**Project# 1002730**  
10DRB-70118 EXT OF SIA FOR TEMP DEFR SDWK CONST

Subdivision Name: VILLA FIRENZE

**DRB CASE NO/PROJECT NO: 1002730**

Final Plat

SHEET 2 OF 2

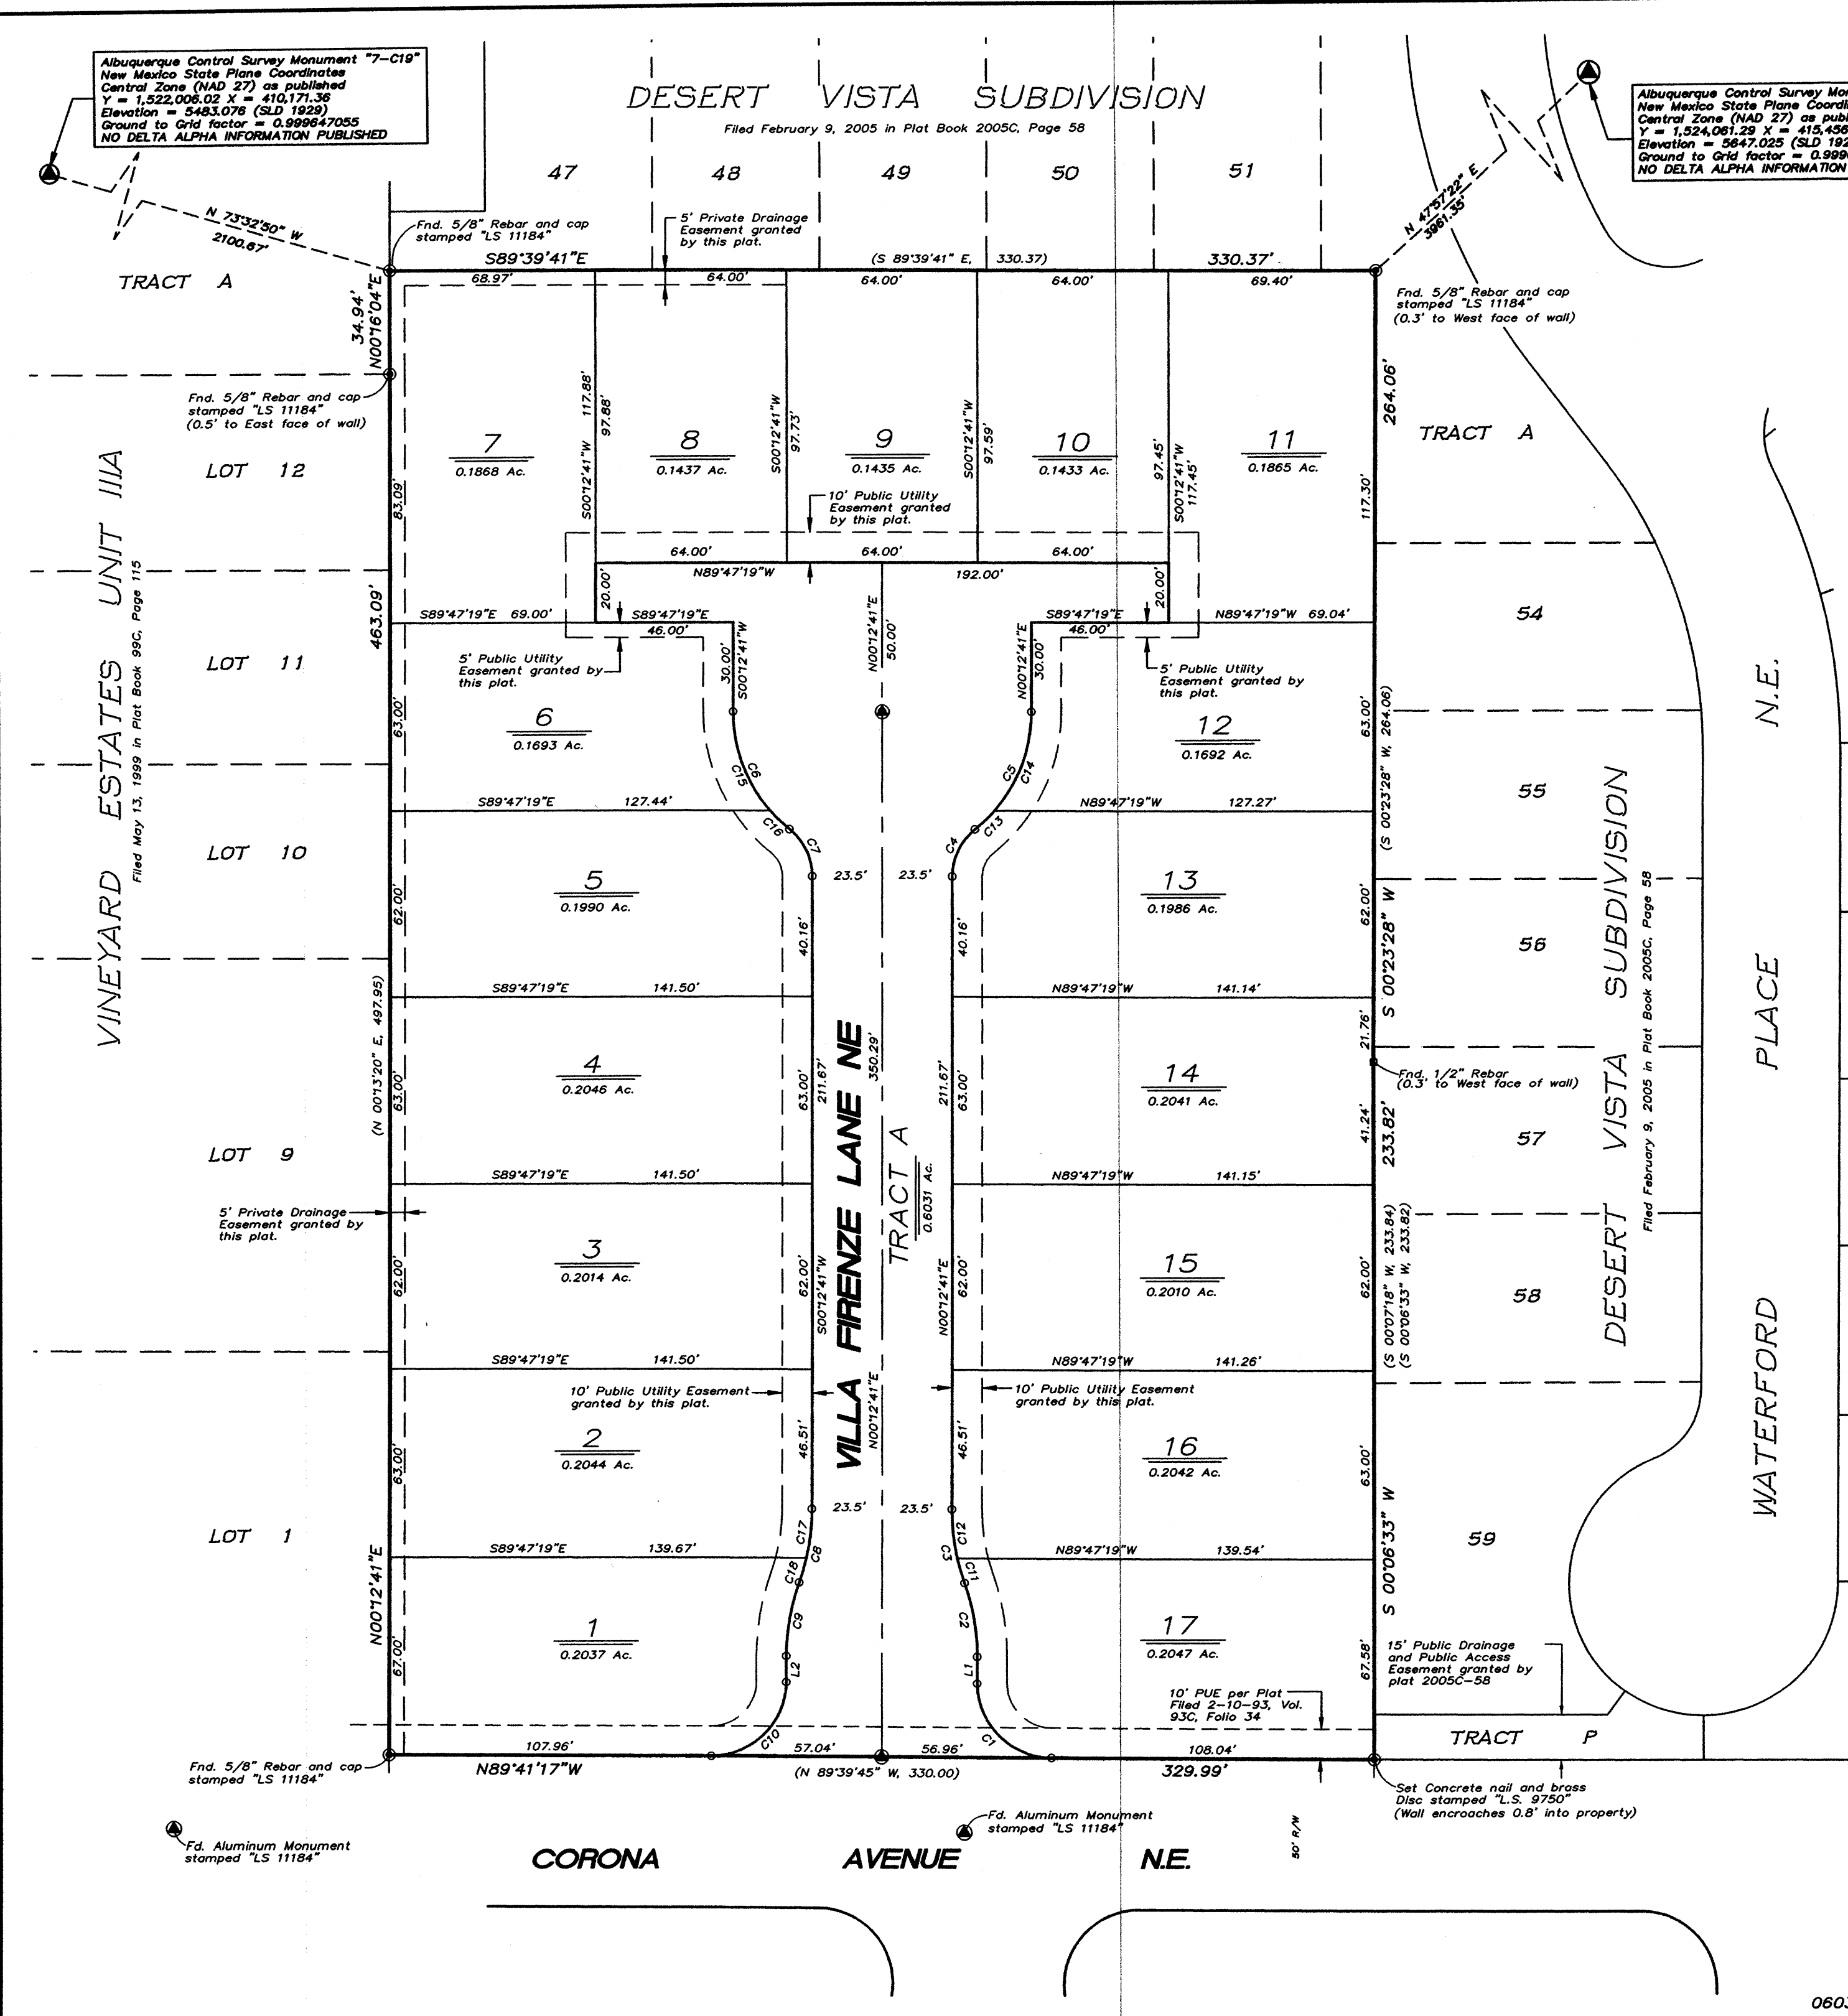
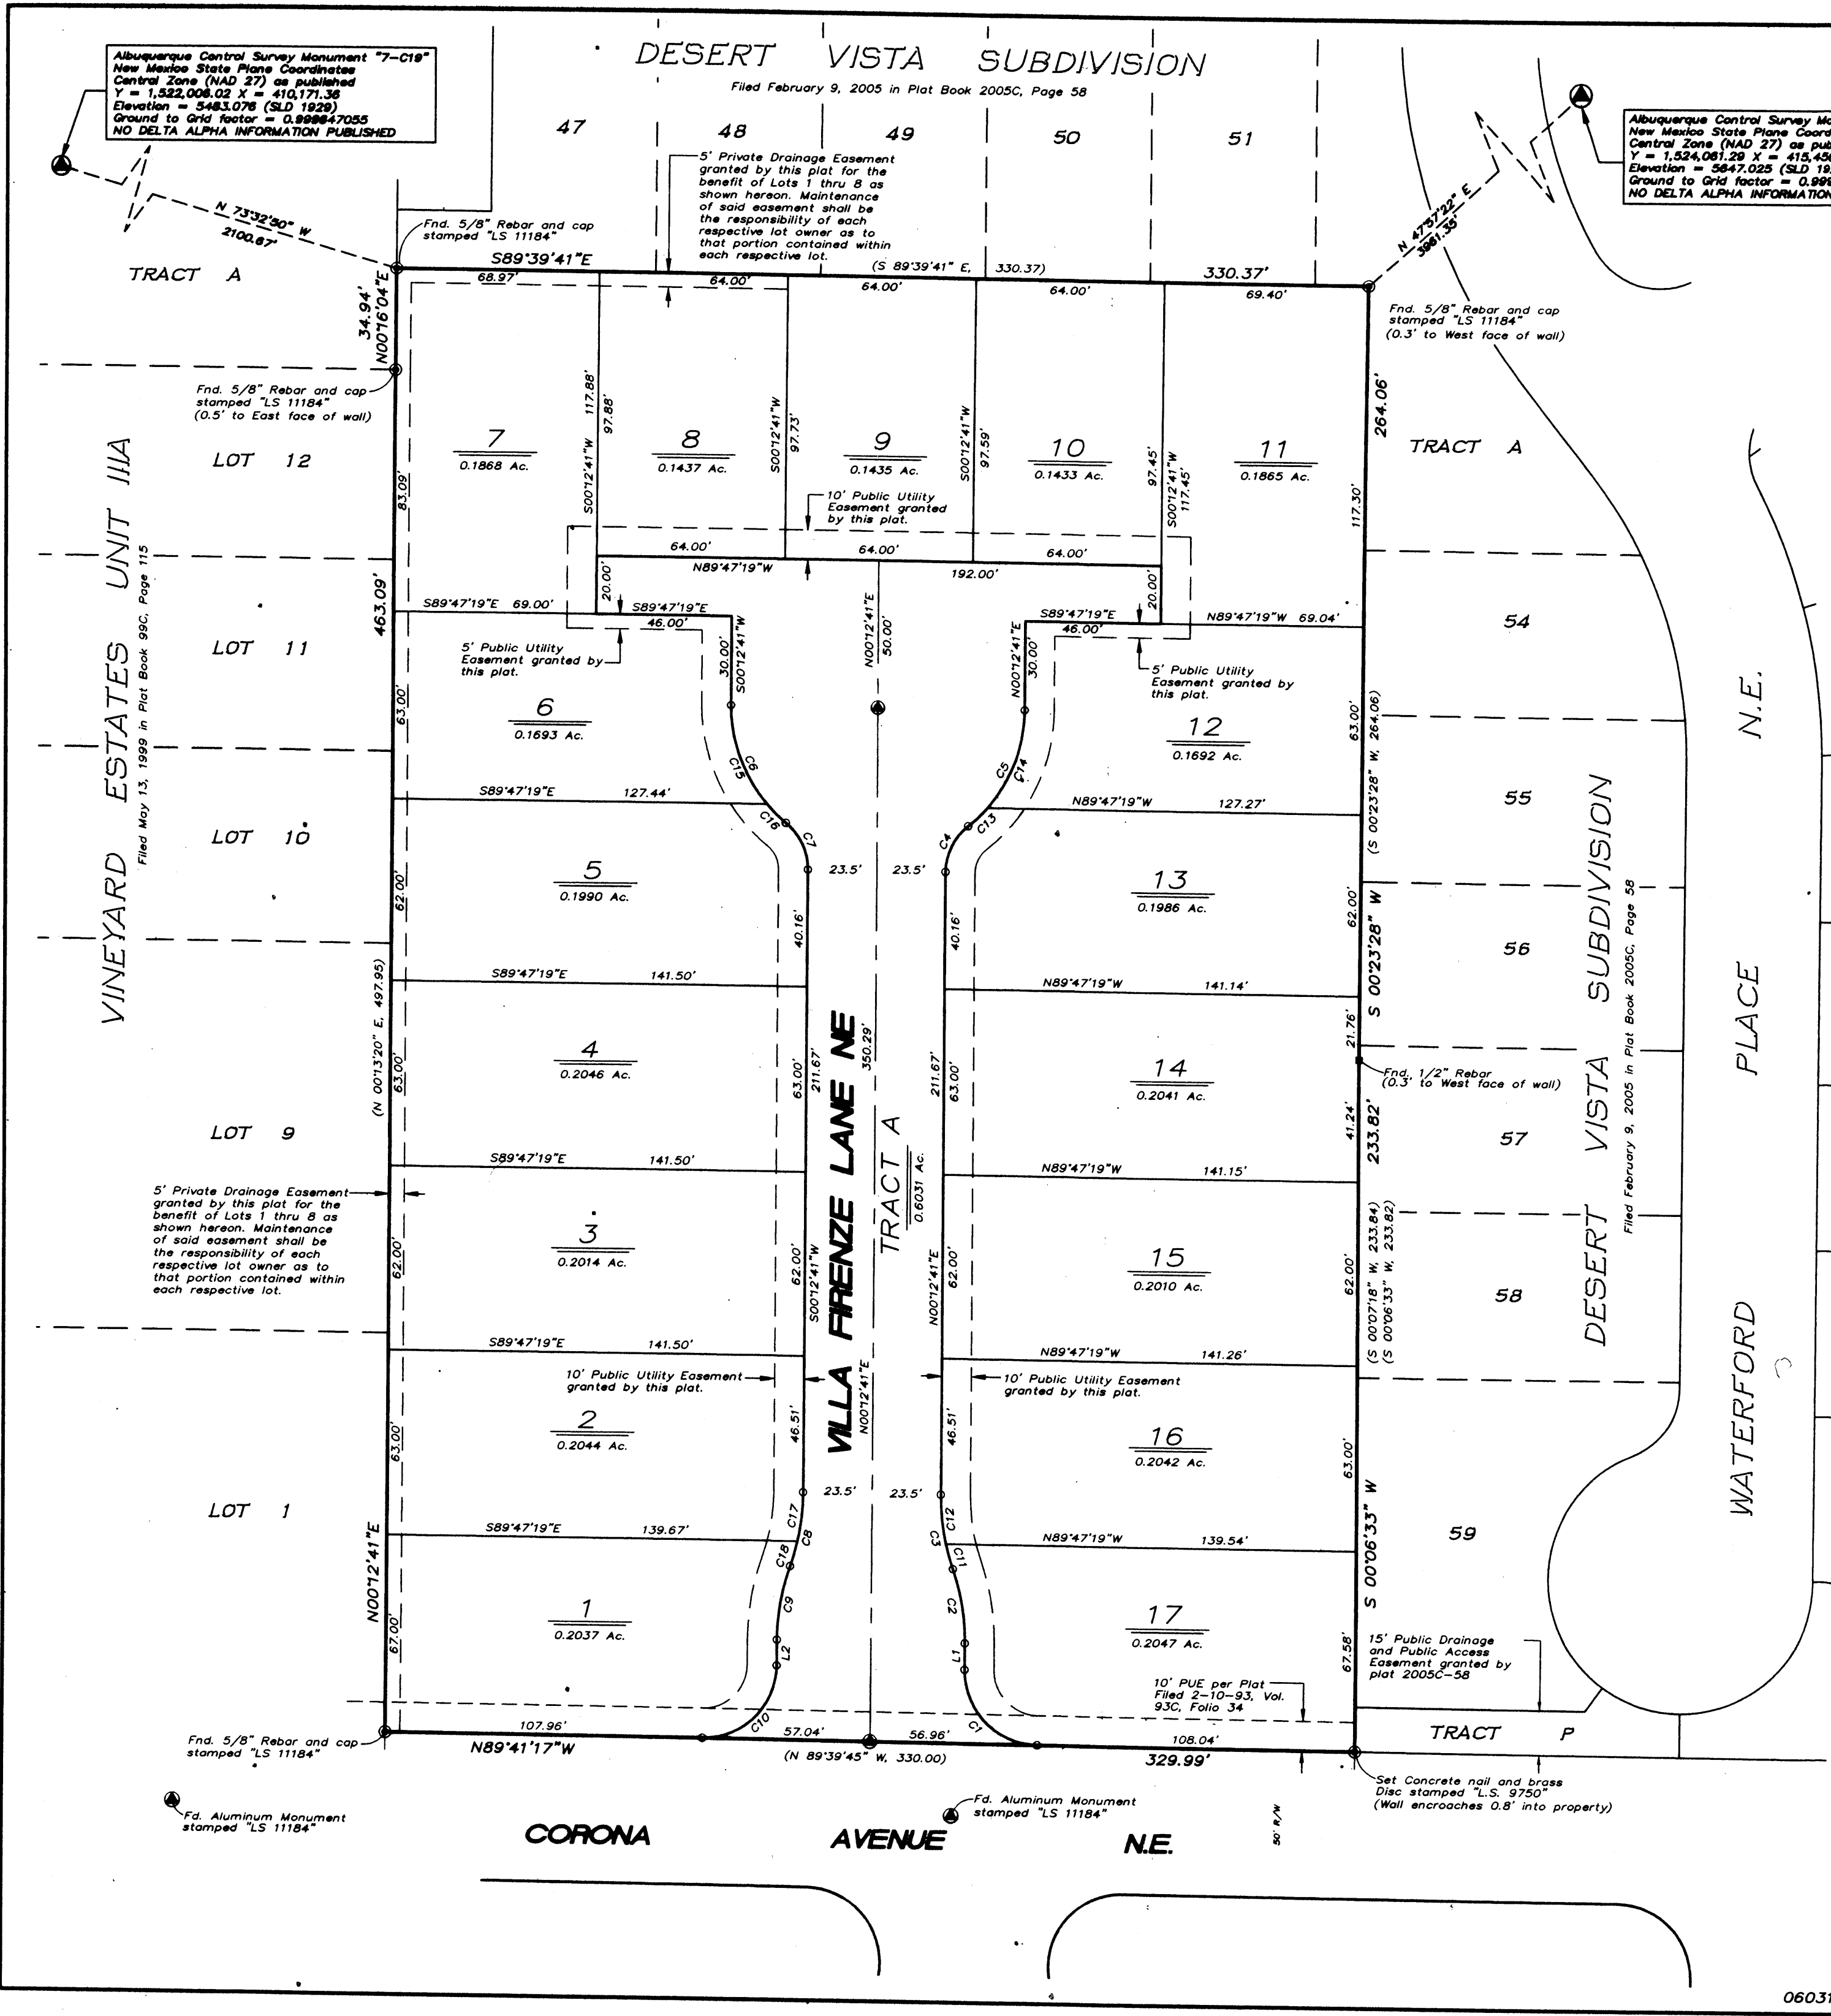
Provide maintenance and beneficiary information for private drainage easement.
